Application for Planning Permission for Works or Extension to a Dwelling

Development: Erection of a garden room. (This application may affect the character and appearance of the Norton Lane, Norton Conservation Area).

Location: The Coach House Norton Lane Norton PO20 3NH

PROJECT:	The Coach House Norton Lane Chichester PO20 3NH
DRAWING:	02 - Existing and Proposed Site Plan
SCALE:	1:500
REV:	
DATE:	01/09/25

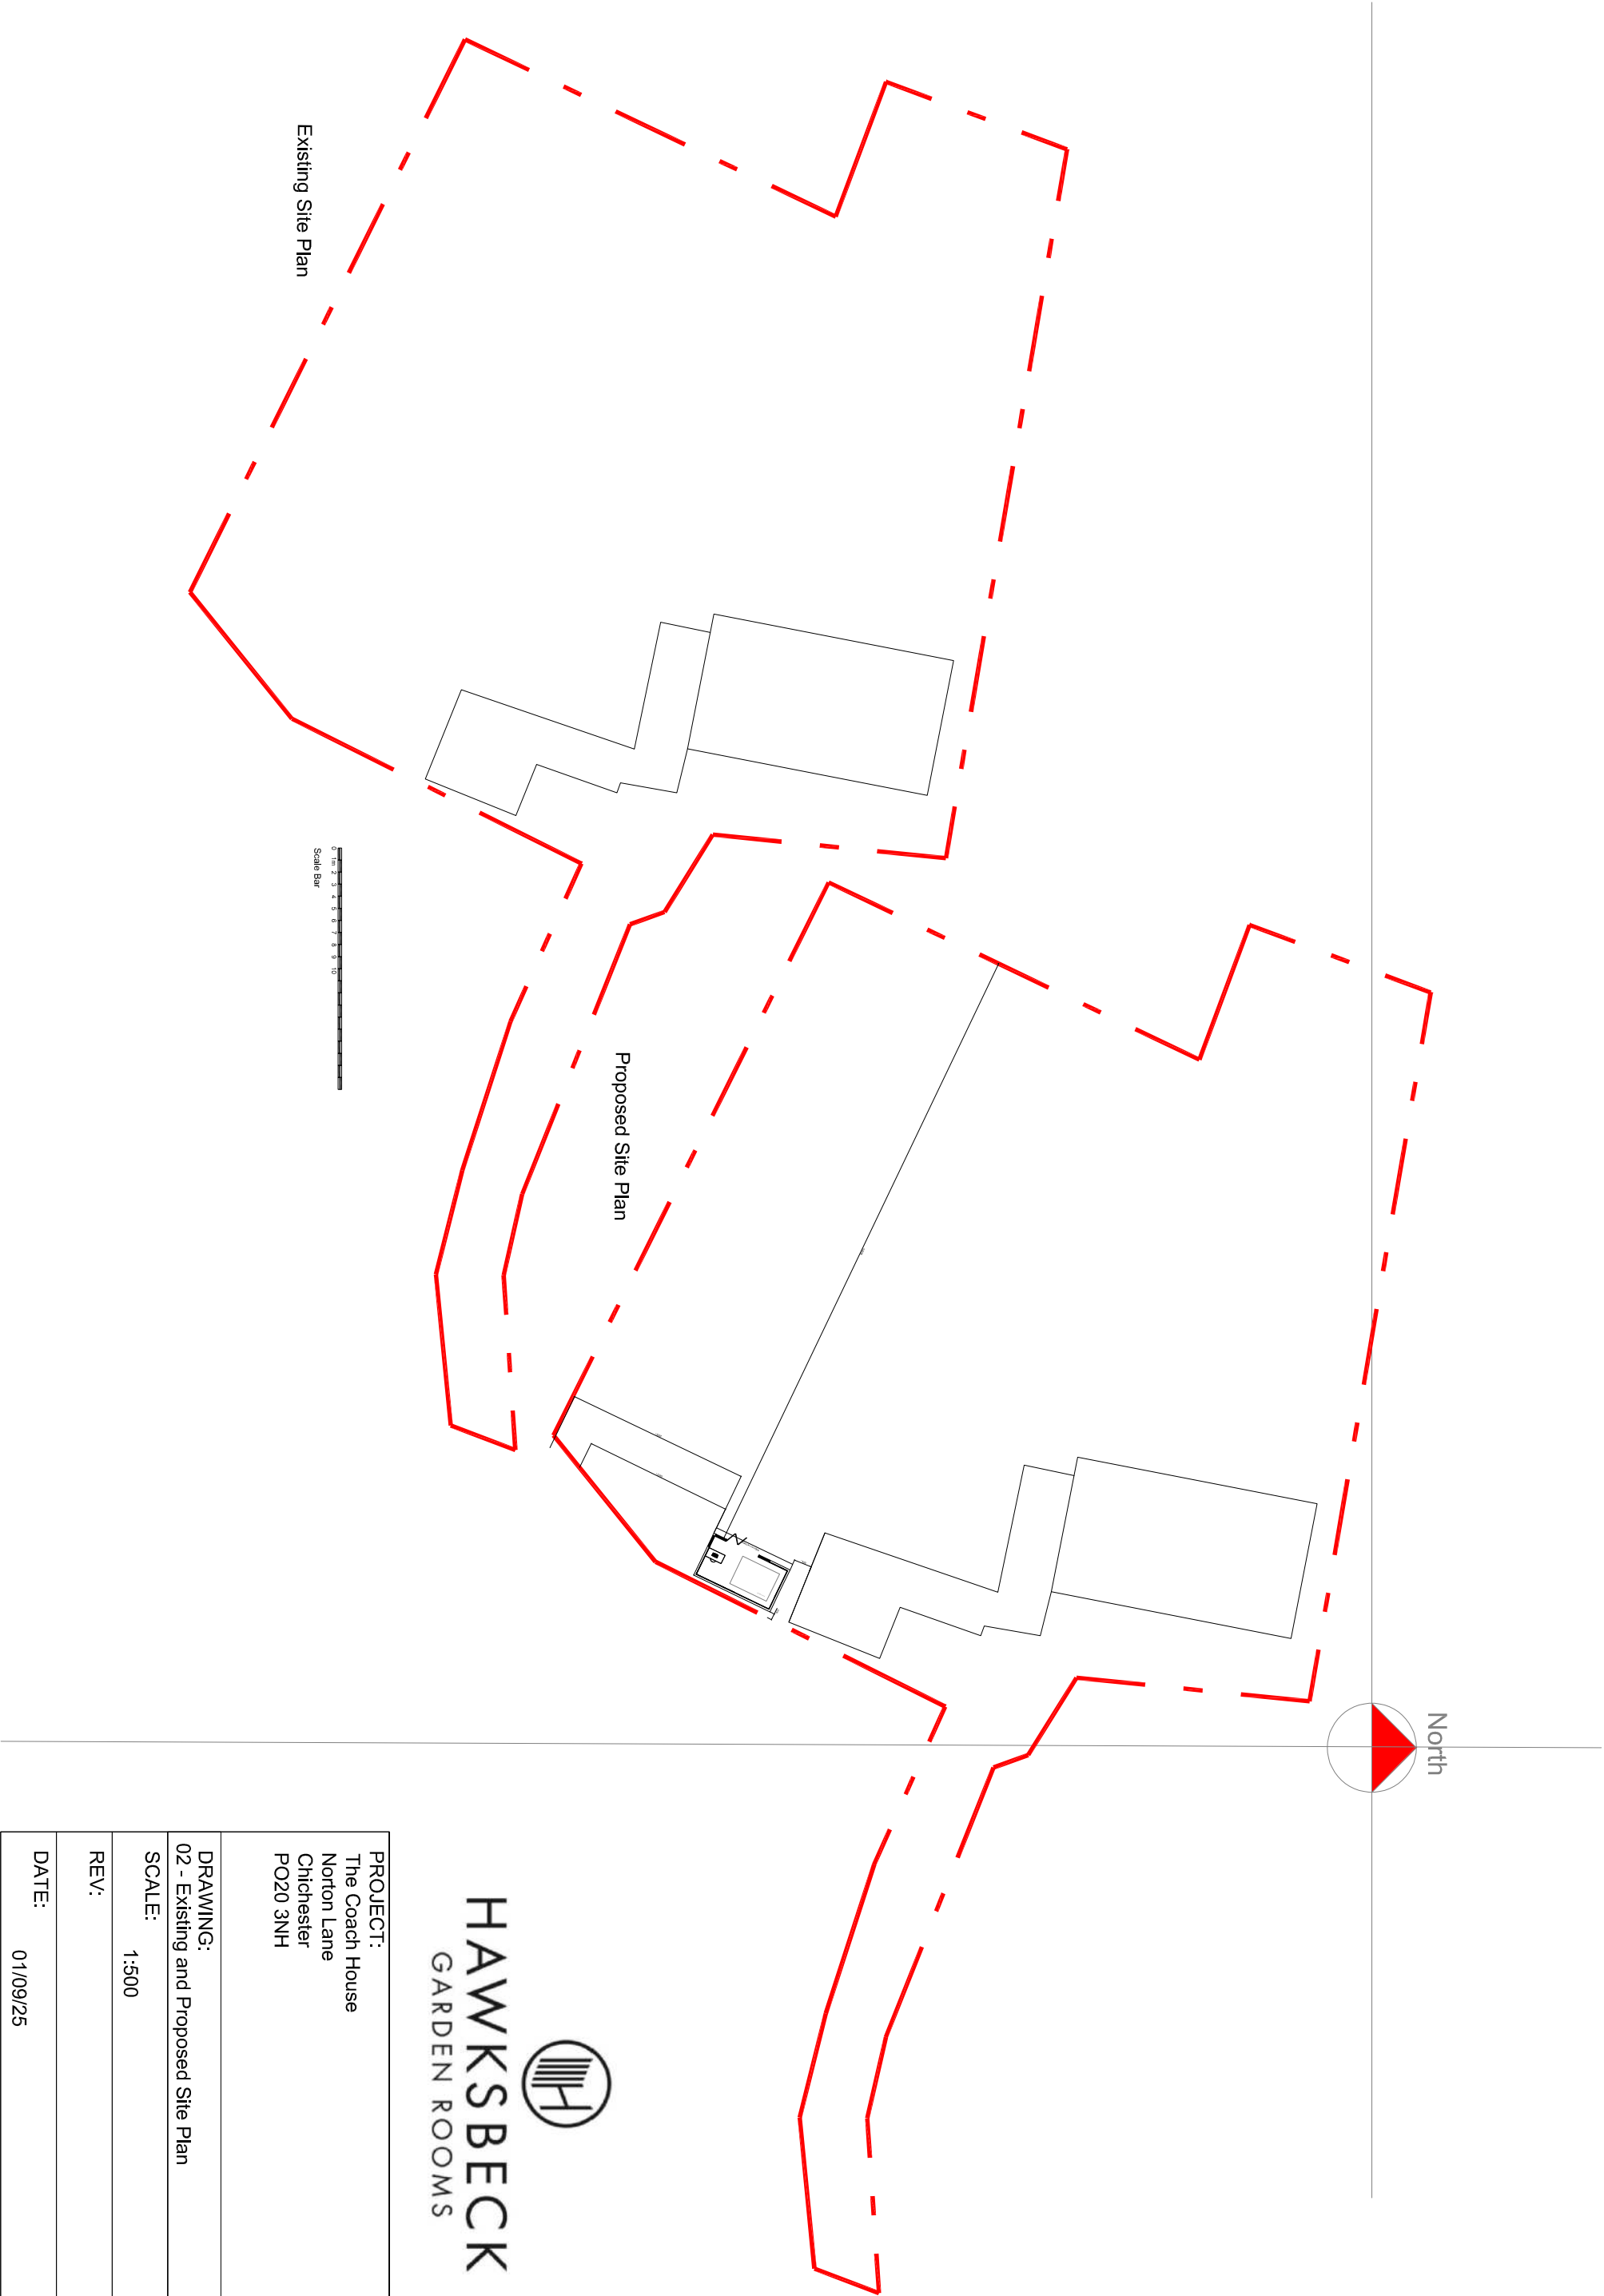
Block Plan

You are required to have dimensions from the proposed extension(s) to all site boundaries. Please amend.
